## **GLEBE FARM MARINA CLAYDON**

**Revised Application Ref. No. 20/02446/F**

### **OBJECTION STATEMENT BY ROBERT ADAMS B.Sc. *Landscape Architect (retired)***

**Proposed Highways Access**  
Scale 1:200

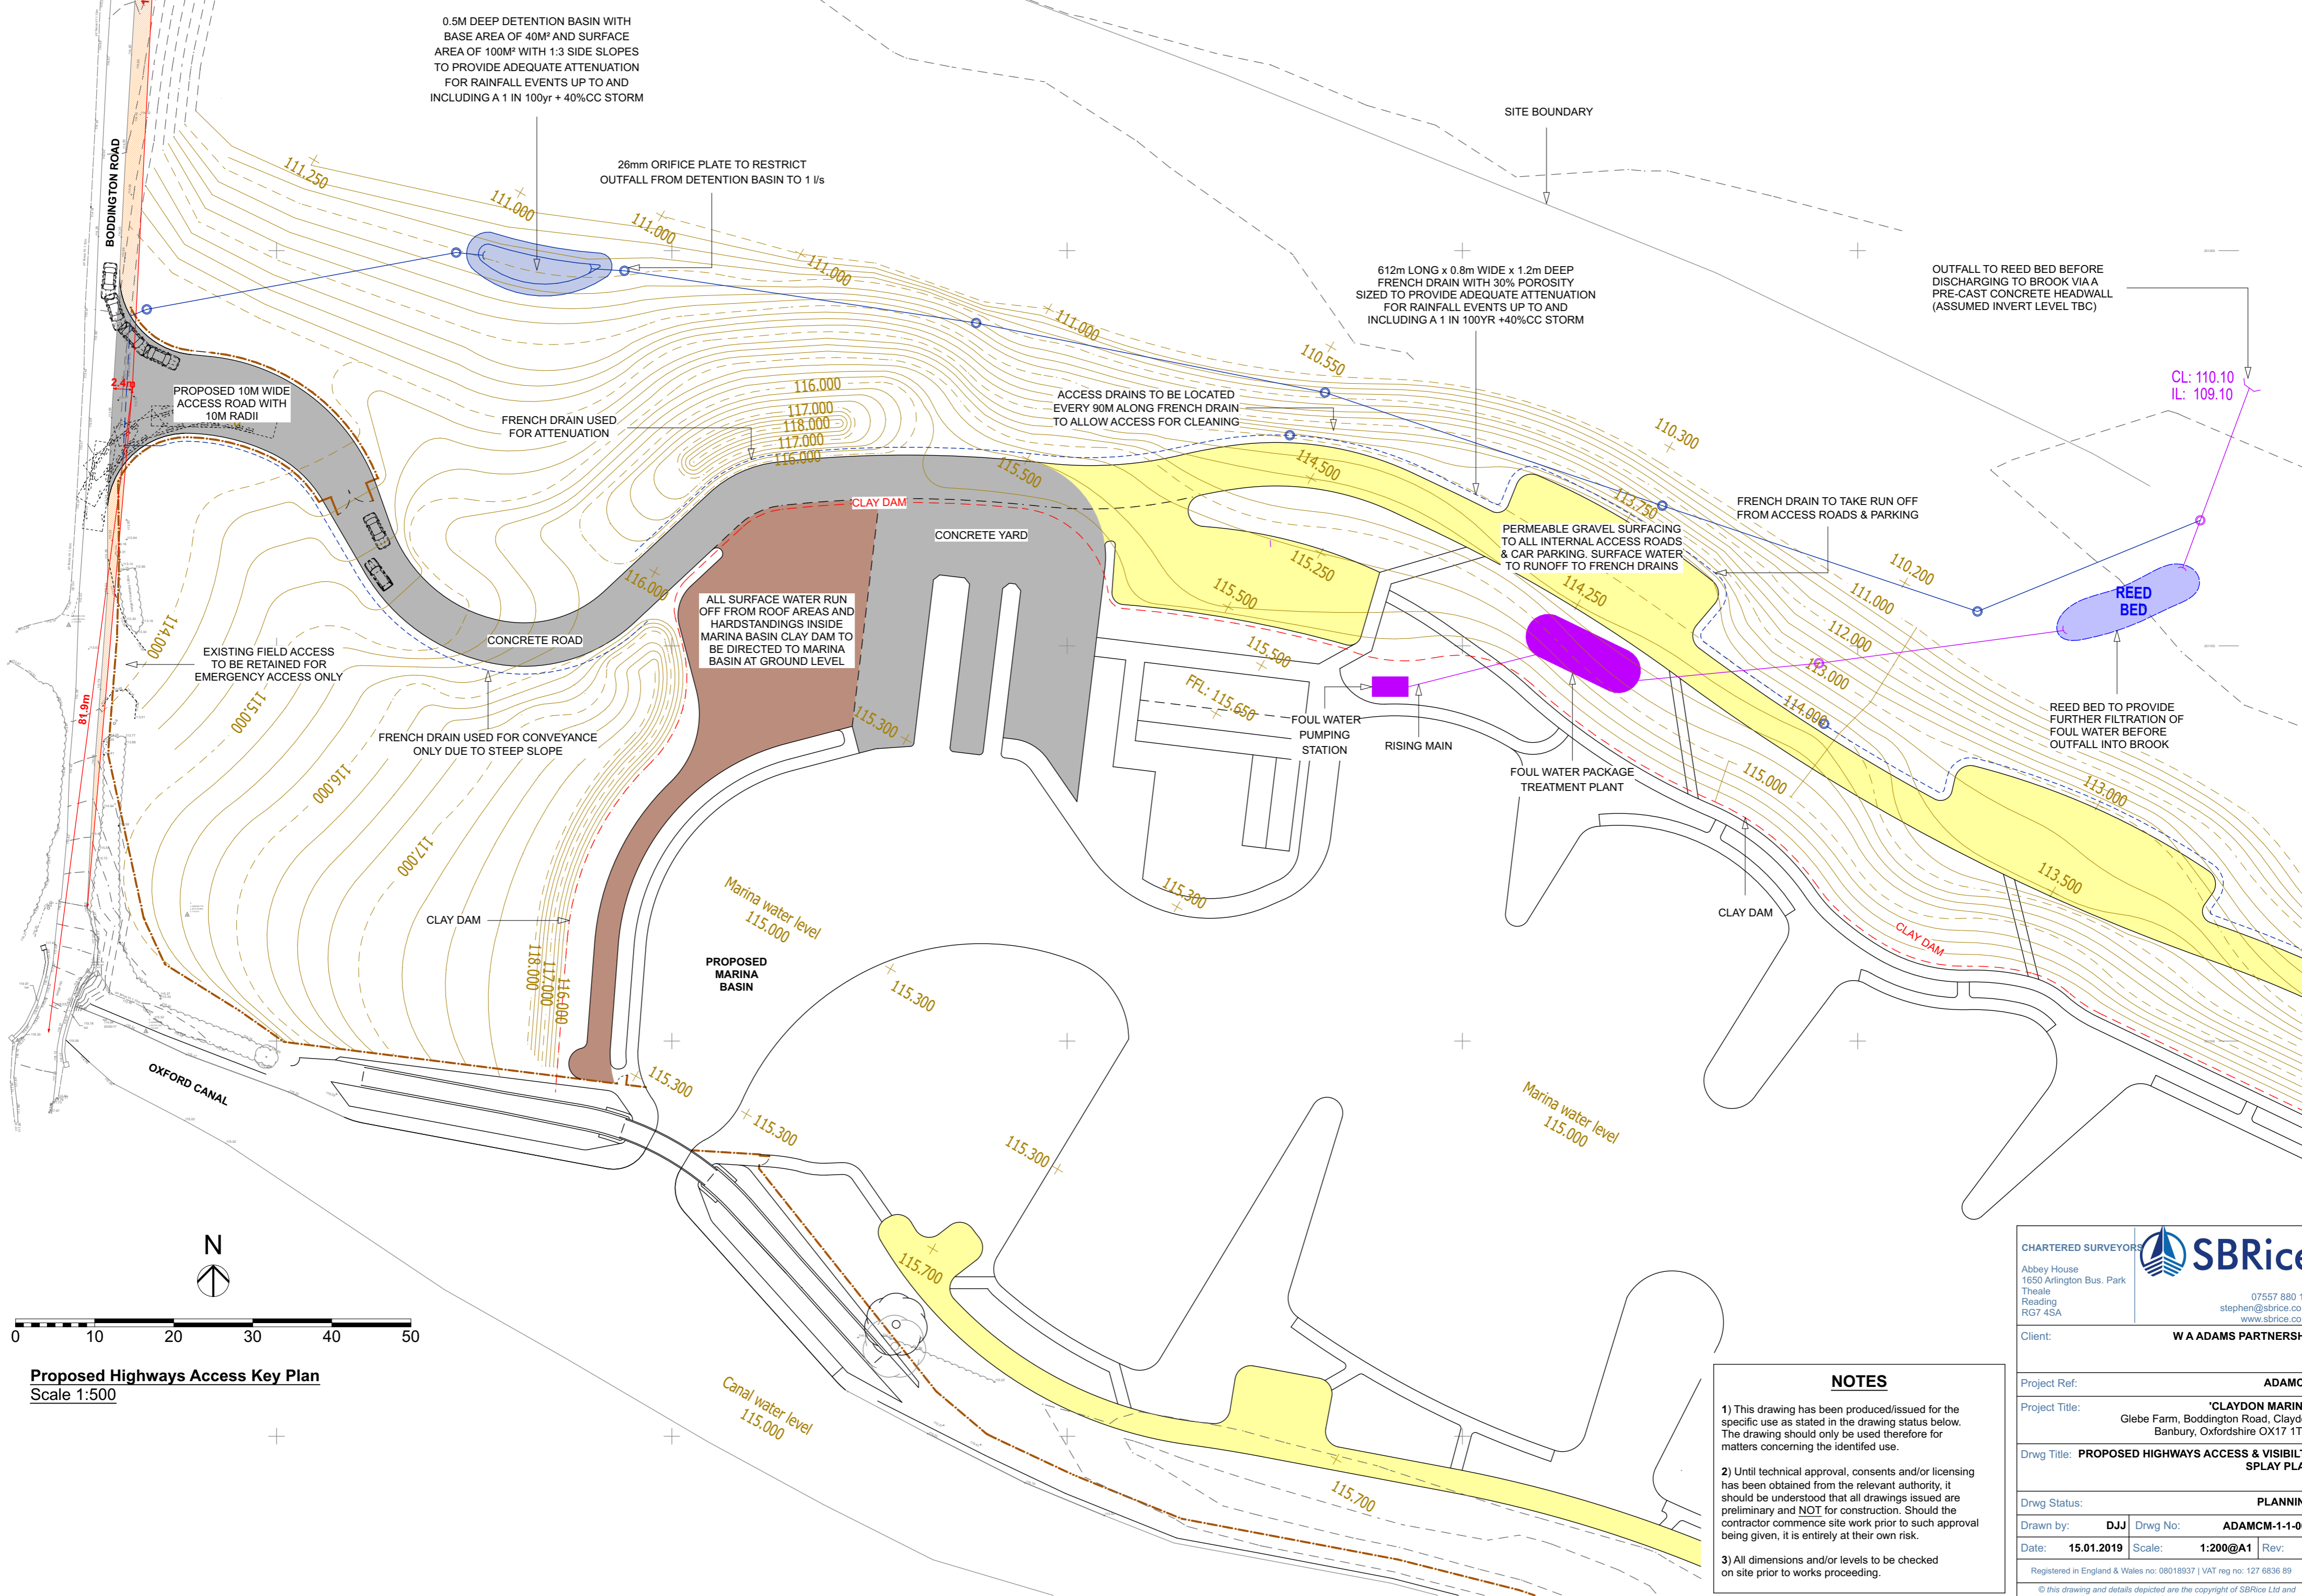
1.2 Highways access along the Lower Boddington Road is very poor with a hump back bridge immediately before the entrance. The Lower Boddington Road from Claydon is within Oxfordshire and north of the site it is in Northamptonshire. Has there been any consultation with Northamptonshire by the applicants? Nothing advised to village.
